Our Ref: BN/28/17/RES
Your Ref:

Application for Approval of Reserved Matters Following Outline Approval

Development Approval of reserved matters following outline consent BN/32/15/OUT relating to appearance, landscaping, layout & scale
Location Land to R/O Lillies Yapton Road Barnham

DRAWING
Plot 1
Floor Plans

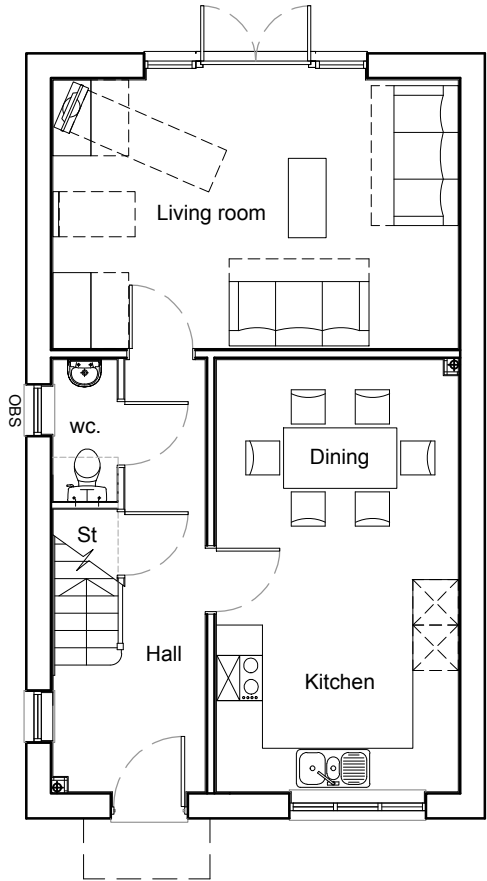
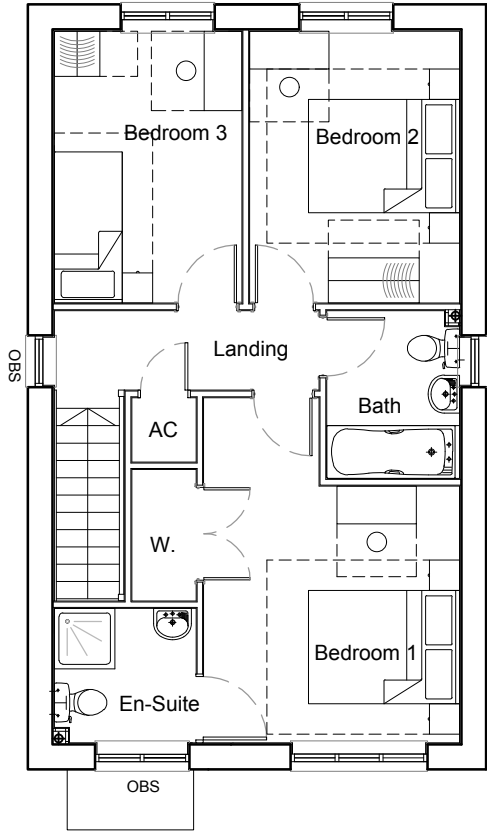
Please note it is not possible to have two options with regards to the elevations. The plans relating to House Types 766, 1102, 1156 & 2B4P have two options, please remove one option from the application.
